**Washington State
Department of Transportation**
Douglas B. MacDonald
Secretary of Transportation

July 7, 2005

Subject: B & T Short Plat (4 Lots); B & T Brunner Family
SR 903, MP 9.07 Right (Tom Write Road Intersection)

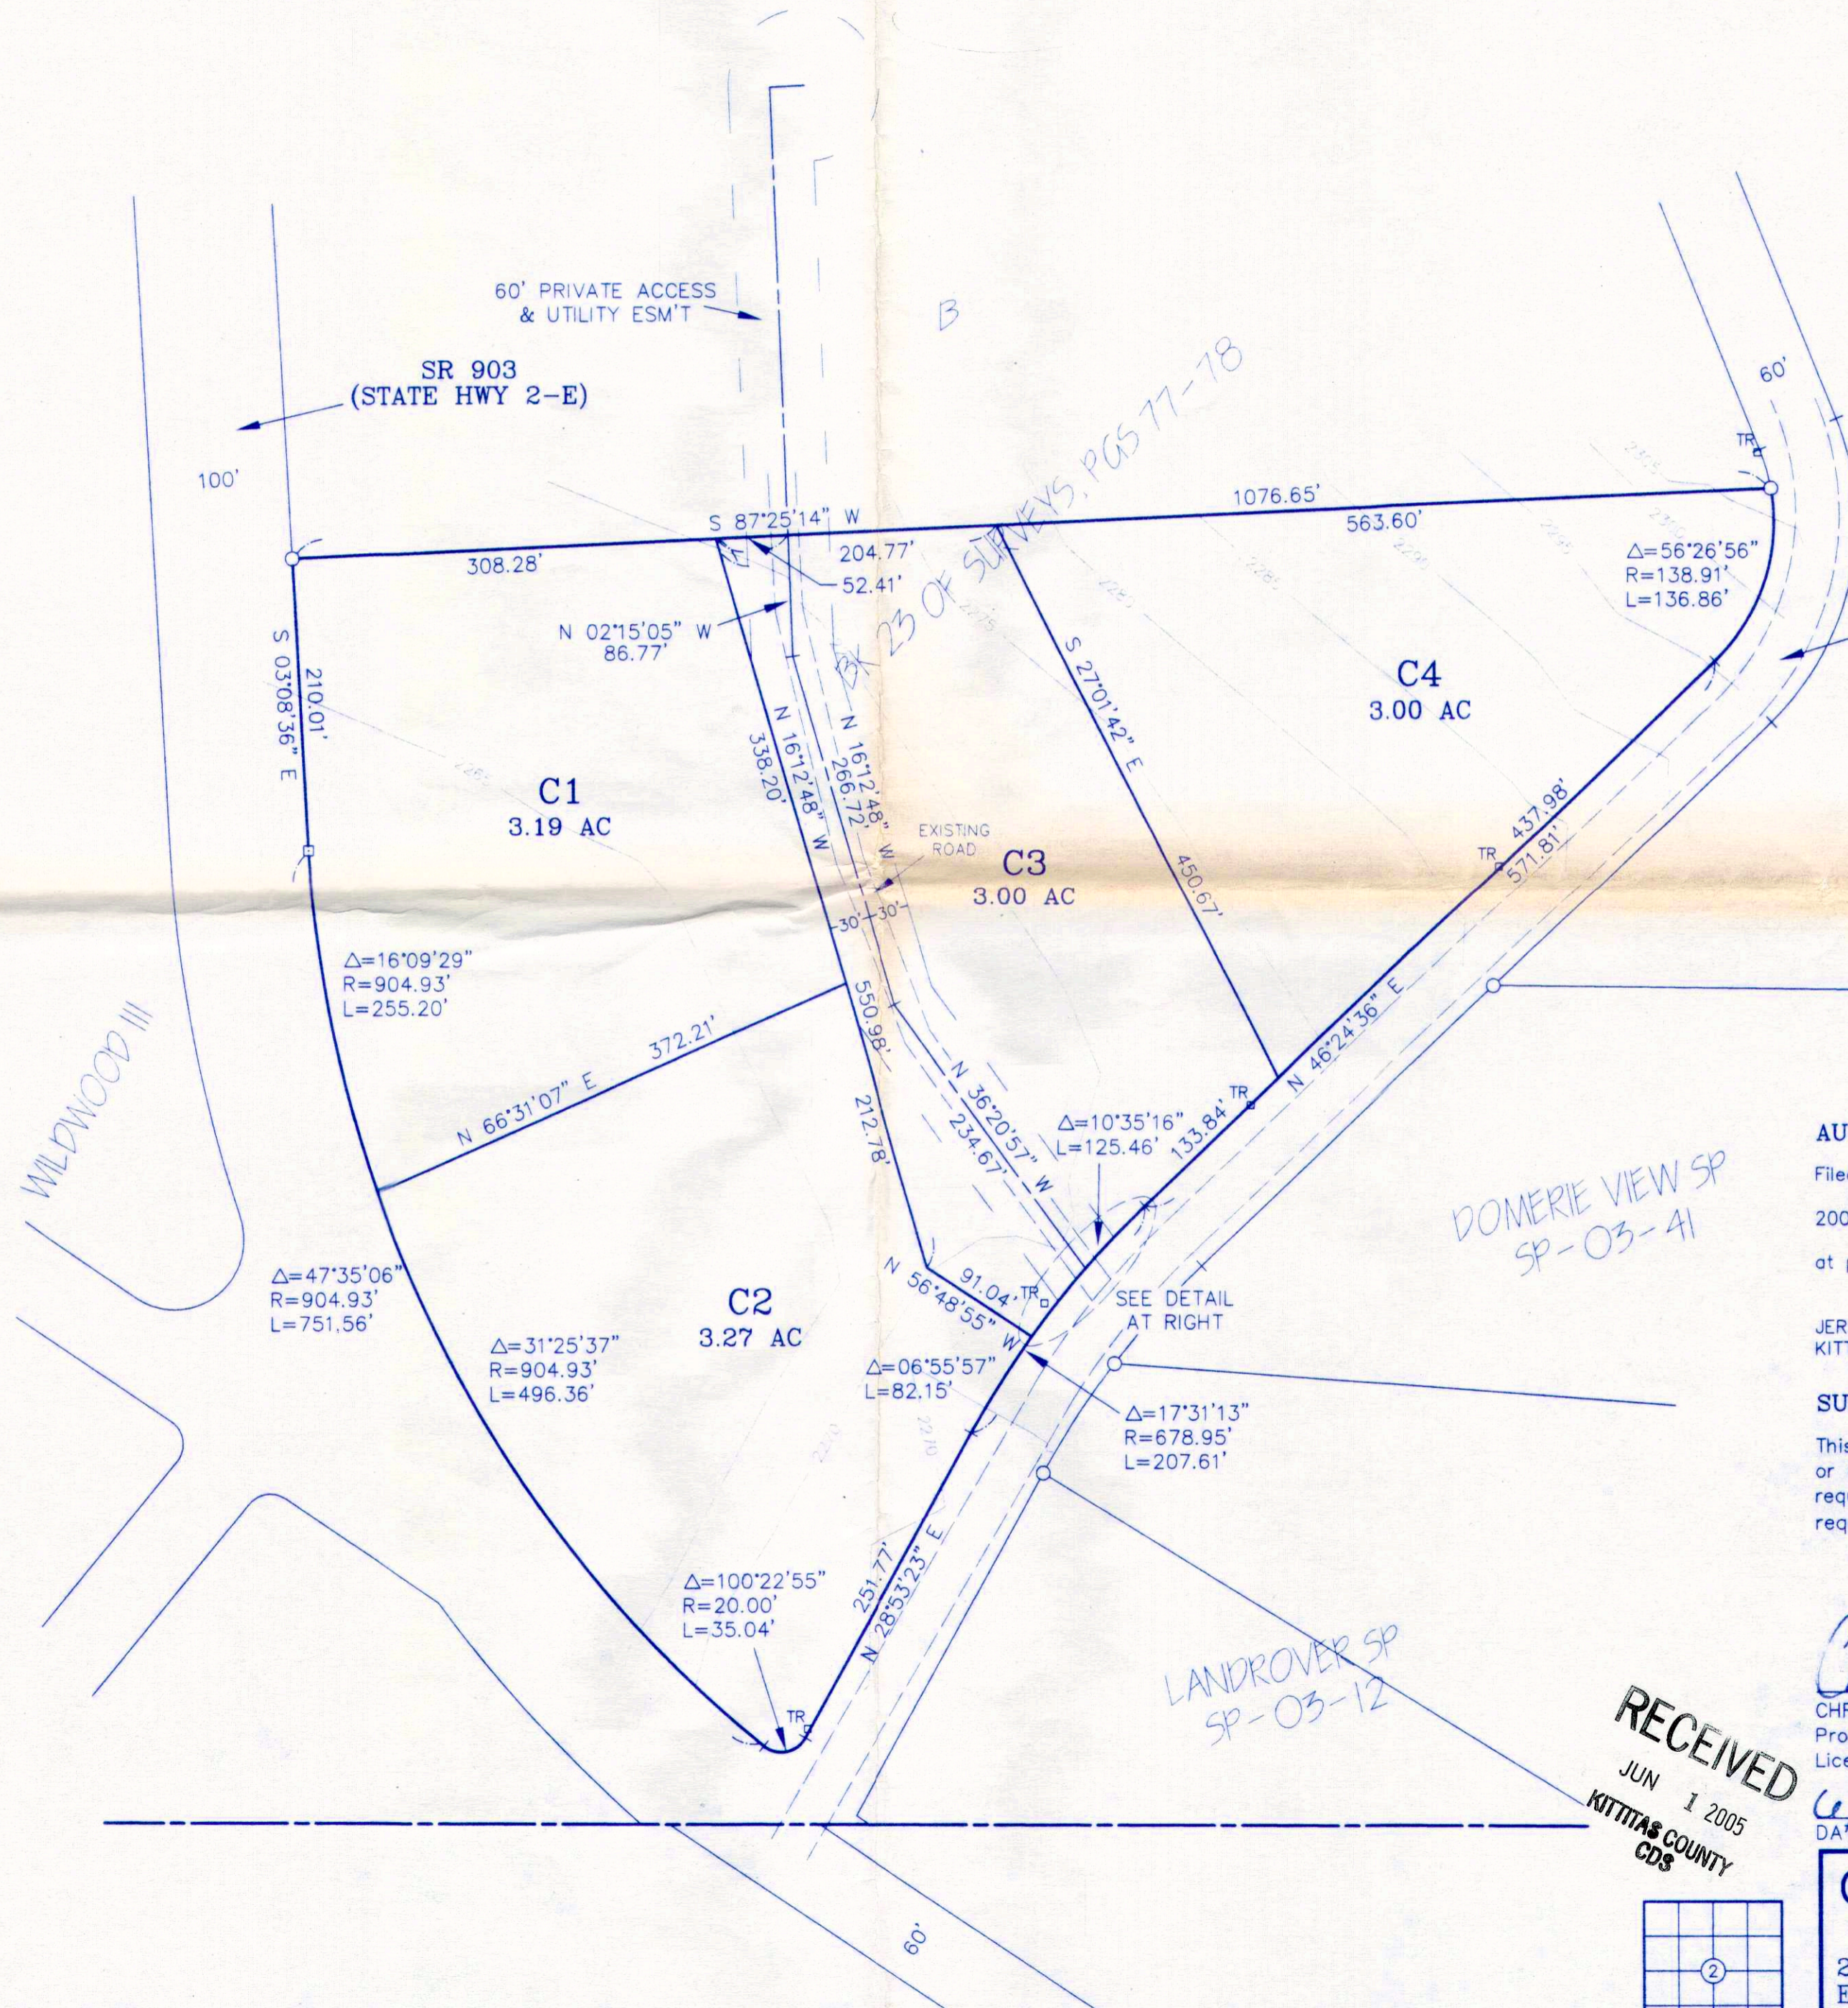
1. The plat property is adjacent to SR 903 and Tom Write Road. SR 903 is a Class 4 access managed highway in this location with a posted speed limit of 50 miles per hour. No direct access to SR 903 will be allowed. We require a restrictive note be placed on the plat indicating no direct access to SR 903 will be allowed for any lot.

The intersection of Tom Write Road does not meet minimum standards for even a private road approach. As a condition of development approval, WSDOT requires that the proponent pave the gravel portion of Tom Write to, at a minimum, the edge of WSDOT right-of-way. The proponent is required to contact Mr. Rick Holmstrom to coordinate the paving improvement. Mr. Holmstrom can be reached at 509-577-1633.

2. Stormwater and surface runoff generated by this project must be retained and treated on site in accordance with regulating agencies' standards, and not be allowed to flow onto WSDOT rights-of-way.
